**Notice of Proposed Modification Application MP 08\_0238 MODs 6 & 7 (North Sydney LGA)**

Thank you for your email message dated 16 November 2016, requesting Transport for NSW (TfNSW) review and comment on the above modification proposal.

4.2 NEW THROUGH SITE LINK

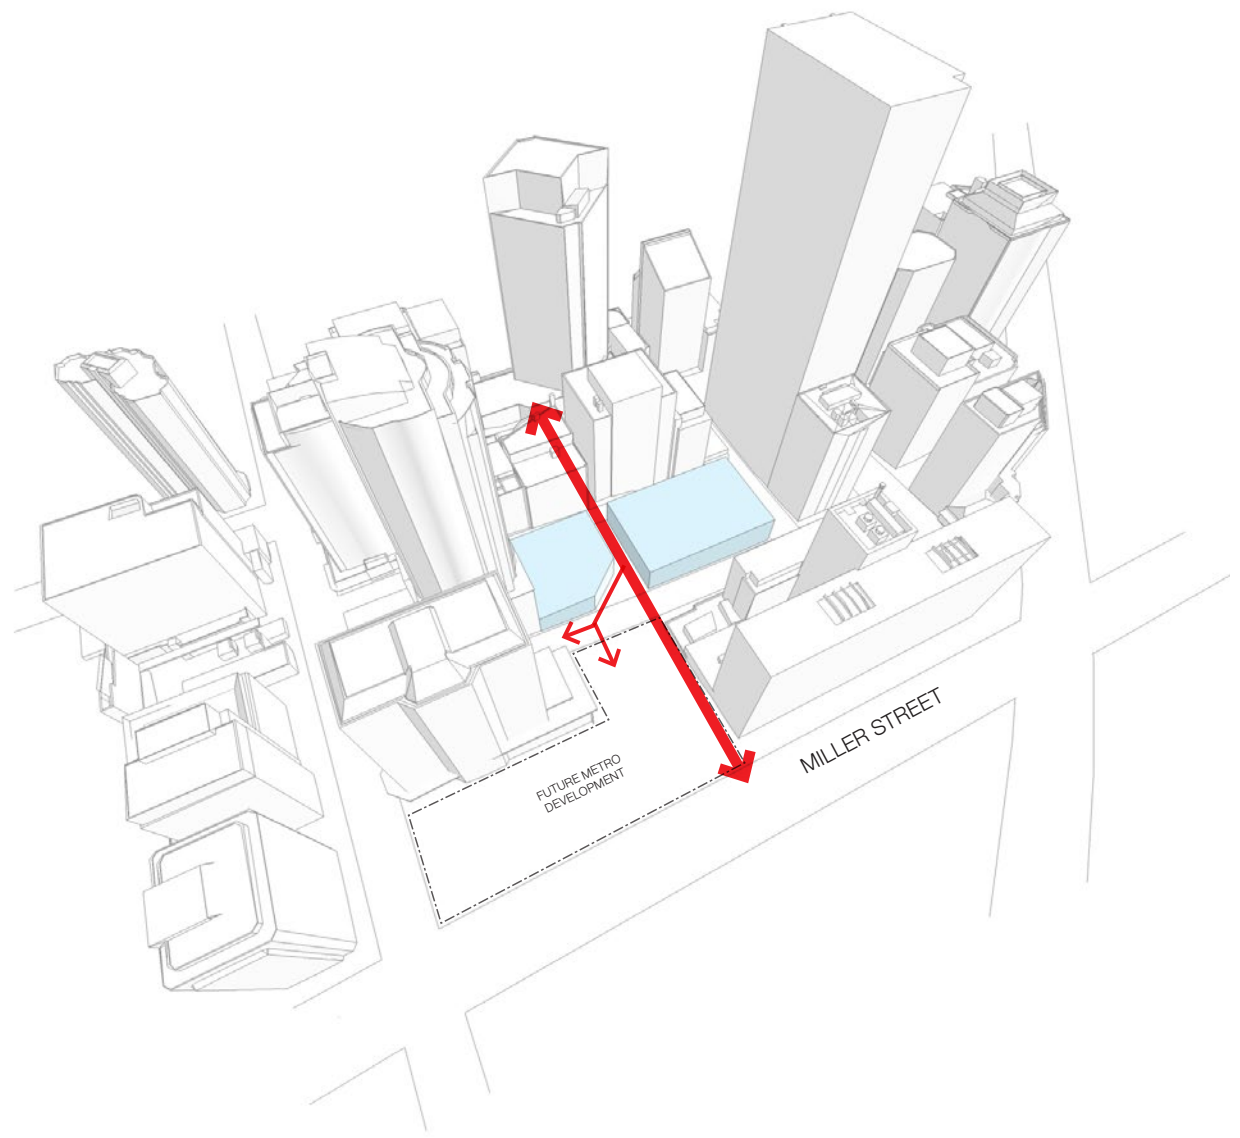
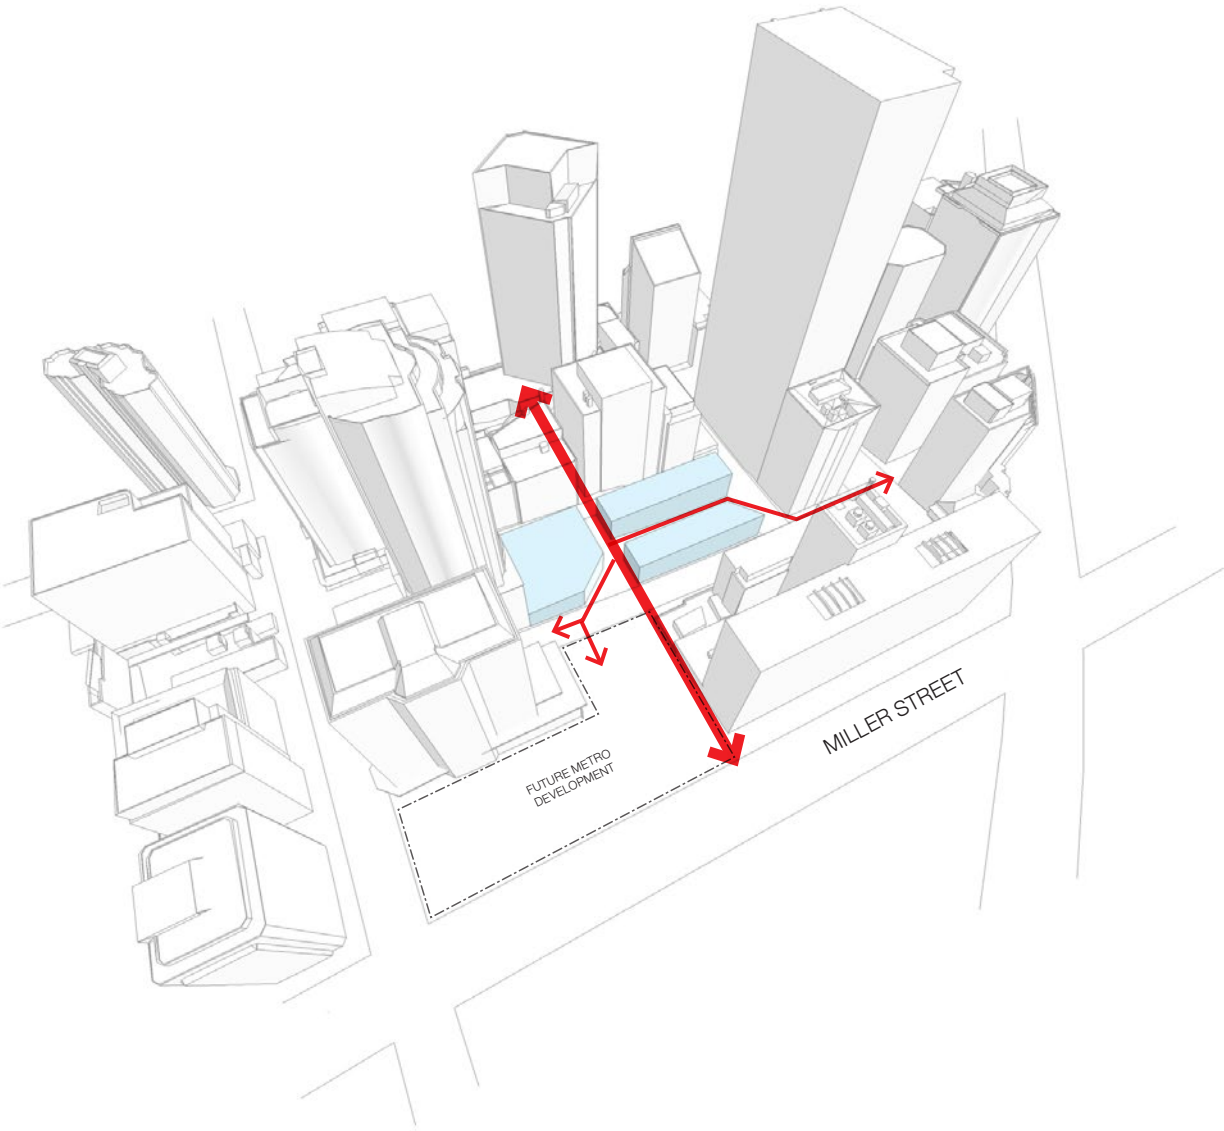
TfNSW advises that the design addresses the context of the delivery of Sydney Metro and plans should facilitate strategies in Council's Sydney Metro Planning Study (May 2016).

TfNSW requests that the following principles be considered in the design:

- Minimisation of road width and maximise pedestrian footpath space;
- Remove parking from the proposed lane;
- Prioritise pedestrian movements;
- Consideration of single paving treatment; and
- Support for retail along the proposed laneway frontage.
